TfNSW Reference: SYD22/01377/01  
Department Reference: SSD-41306367

**EXHIBITION OF EIS- CONSTRUCT NEW GREGORY HILLS PRIMARY SCHOOL- 28 WALLARAH CIRCUIT, GREGORY HILLS**

TfNSW has reviewed the submitted information and provides the following comments for your consideration in the determination of the application:

Figure 17: Pedestrian Access Concept Plan

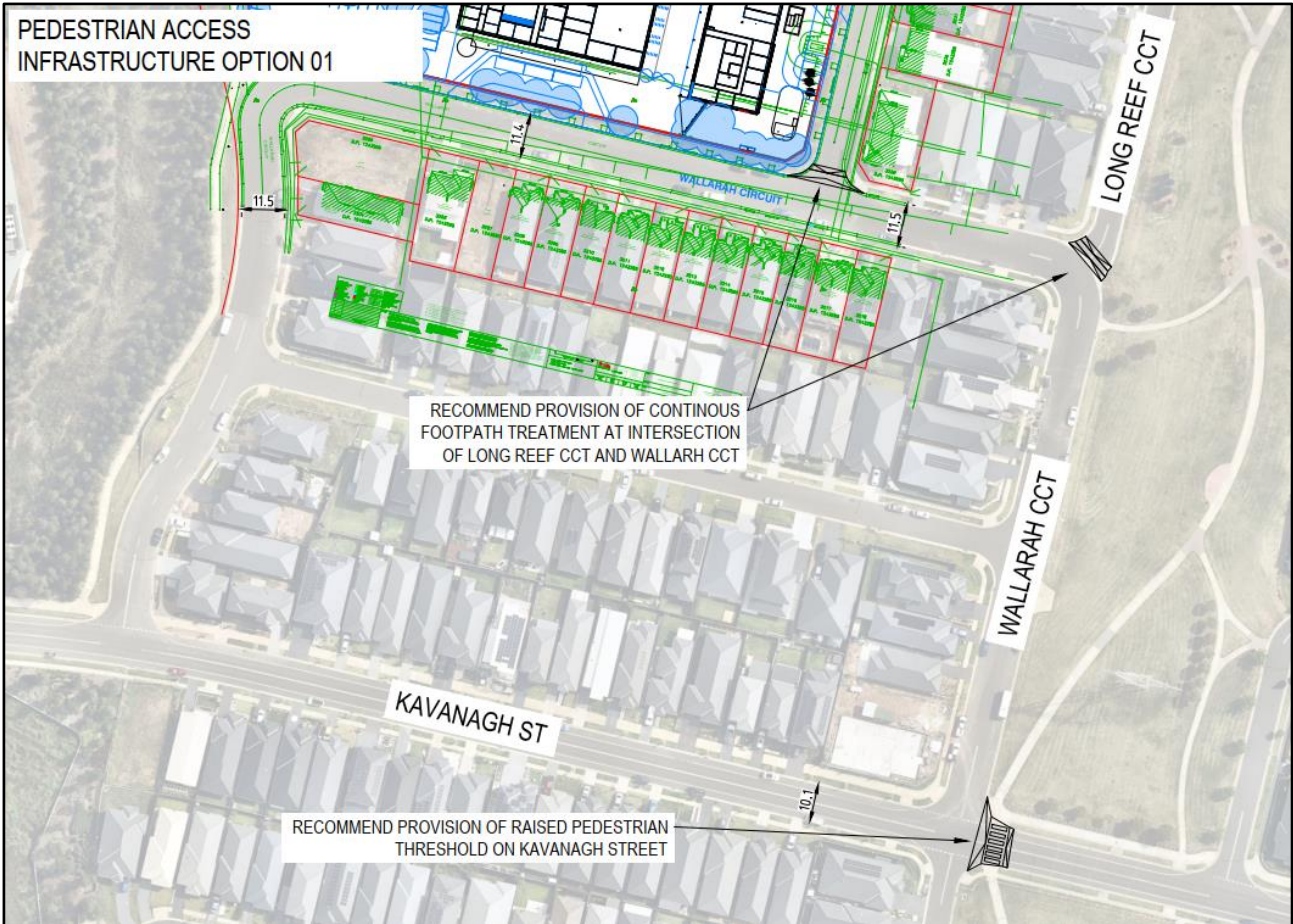
3. TfNSW advises the proposed continuous footpath treatment on the eastern side of Long Reef Circuit requires a tie-in to the existing footpath network. Further clarification should be provided with regards to provision of a continuous footpath treatment (as per drawings) or a Wombat Crossing (item 8 of Transport Working Group mtg 1) on corner of Long Reef and Wallarah Circuit.

4. The proposed Kavanagh Street crossing should be shifted west as much as allowed by the pedestrian desire line.
5. Queuing of westbound traffic to turn right into Wallarah Circuit may obscure sightlines for eastbound vehicles and northbound pedestrians. Further assessment should be provided with regards to this matter.
6. Consideration shall be given to designing the proposed crossing on Kavanagh Street to cater for cyclist as there are high quality off-road cycling facilities to the north and south.
7. Wombat crossing is preferred over Zebra crossing with speed humps on Kavanagh Street.
8. TfNSW advises a warrant assessment for pedestrian crossings is not required on local roads as per the Pedestrian Crossing Guideline (2022).
